Reference: Block 14 (Bridlewood Trails – Phase 2 Subdivision)
Stormwater Management Report
Our File No. 114013

The storm HGL analysis for the Block 14 development has been revised to address the following outstanding comment provided by the City on December 21, 2018:

DRAWING NAME	PROJECT No.
GENERAL PLAN OF SERVICES	114013
DRAWING No.	REV
114013-GP	REV #9

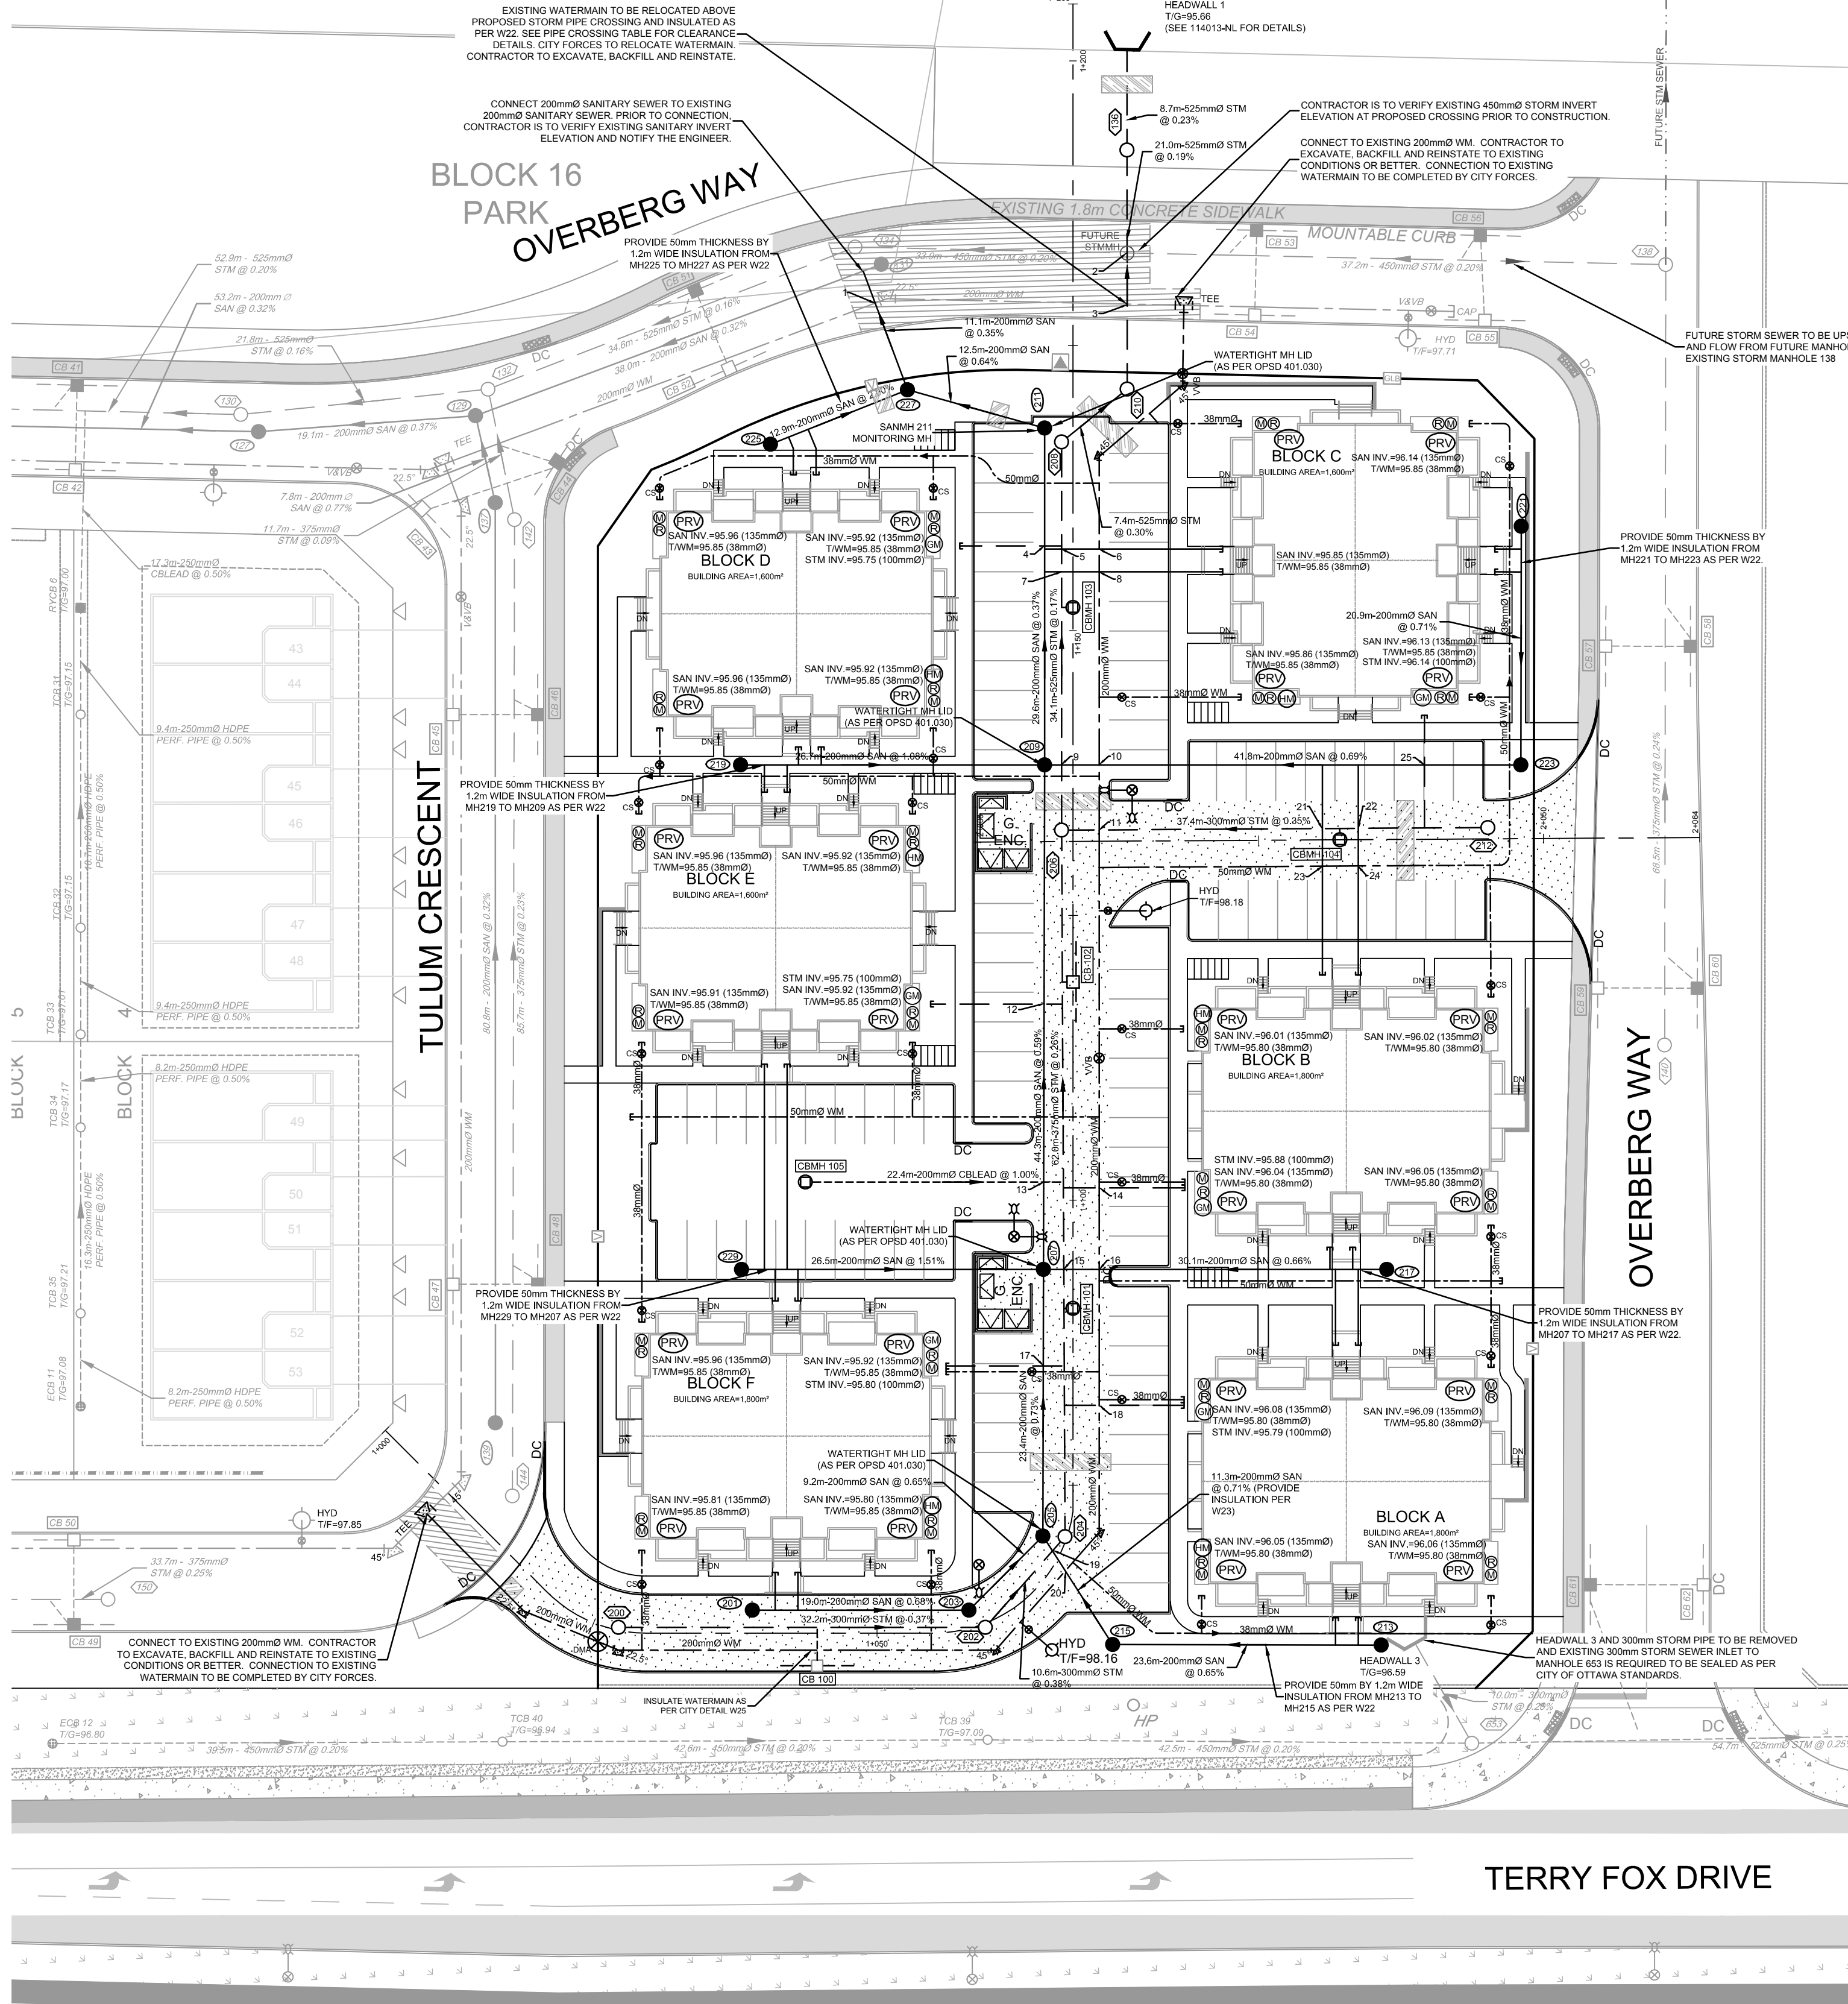
Please provide confirmation that the assumption that the downstream HGL is equal to the downstream pipe obvert is accurate.

In the January 2019 SWM report, a fixed downstream boundary condition of 95.30m was applied to the Block 14 outlet and used to evaluate the storm HGL for the 100-year and stress test (100-year+20%) events. This elevation represents the obvert of the receiving storm sewer, based on the preliminary storm sewer design for the future Bridlewood 3 development.

Since the January 2019 report submission, Novatech has completed the first Draft Plan Submission for the downstream Bridlewood 3 development, which includes a PCSWMM model of the proposed Bridlewood 3 storm sewers. The results of the Bridlewood 3 HGL analysis indicates that the 100-year water level in Cell 2 of the Monahan Drain will surcharge the storm sewers, and the HGL at the outlet from Block 14 outlet is 95.61 (0.31m above the pipe obvert). The downstream boundary condition for the stress-test event has been similarly revised to 95.65m. The revised HGL elevations for Block 14 are outlined in **Table 1** on the following page.

As indicated in **Table 1**, the HGL elevations within Block 14 for both the 100-year and 100-year+20% storm events are still at least 0.30m below the USF elevations of the proposed buildings, and there are no changes required to the grading and servicing design resulting from the updated HGL analysis.
